MERIDIAN SERVICE METROPOLITAN DISTRICT WATER TREATMENT PLANT EXPANSION

PCD File No. PPR-22-012

MERIDIAN SERVICE METROPOLITAN DISTRICT
WATER TREATMENT PLANT EXPANSION
GRADING AND EROSION CONTROL PLAN

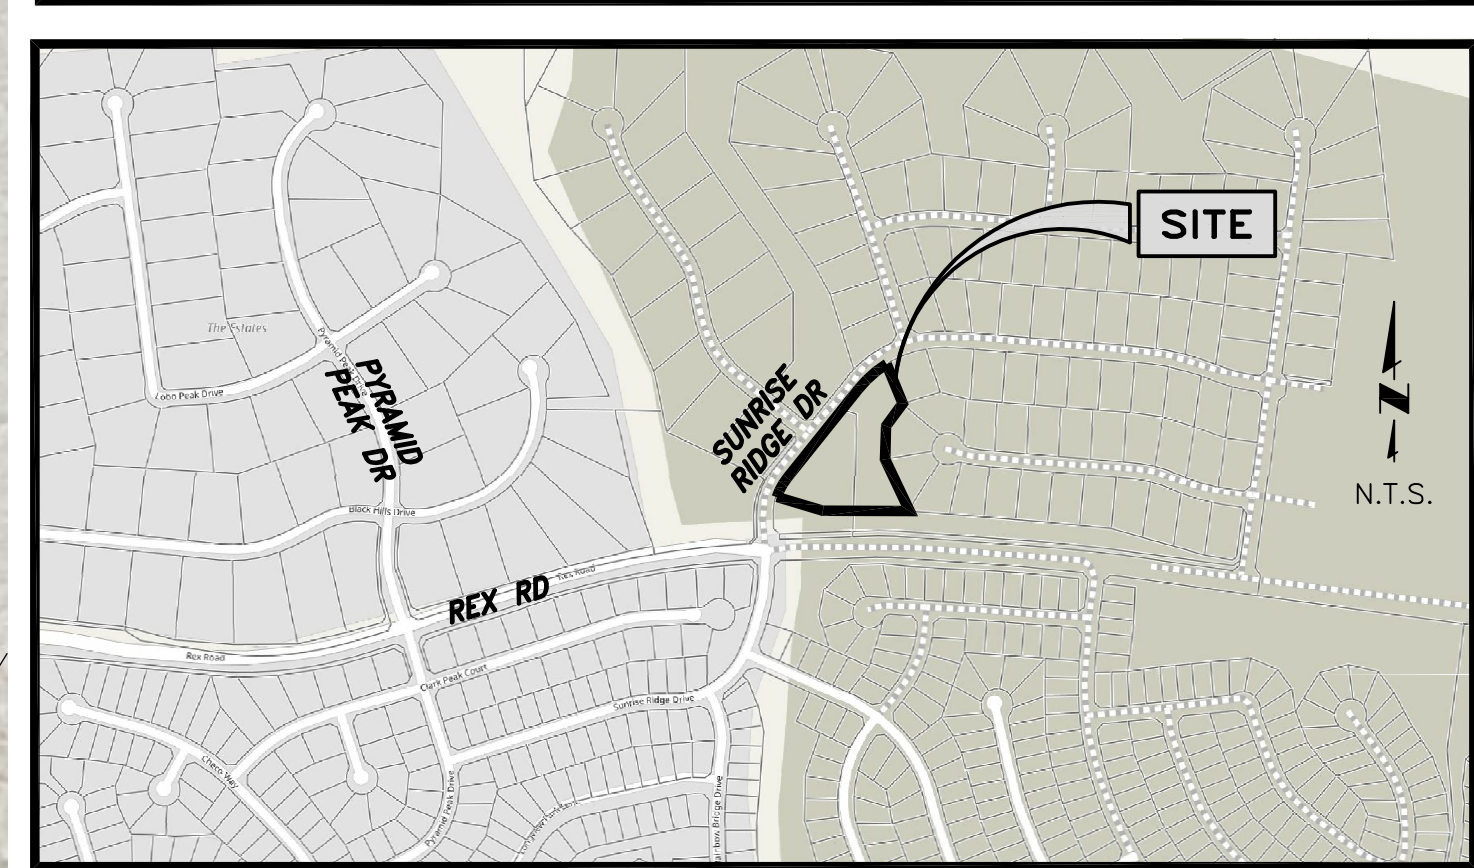
Show Limits of disturbance

GEC Checklist Item bb. call out RPA and put swales in a drainage easement.

TSB (Initial) should be installed prior to discharge from the Site. TSBs are temporary and provide WQ during construction before the swales and all other disturbance is established and vegetated. They are required for all sites with >1ac disturbance.

Provide details of temporary sediment basin including riser pipe diameter and perforation sizing, number of rows of holes, required volume, location of outlet pipe and spillway, and tributary area to the sediment basin. And provide contours for sediment basin.
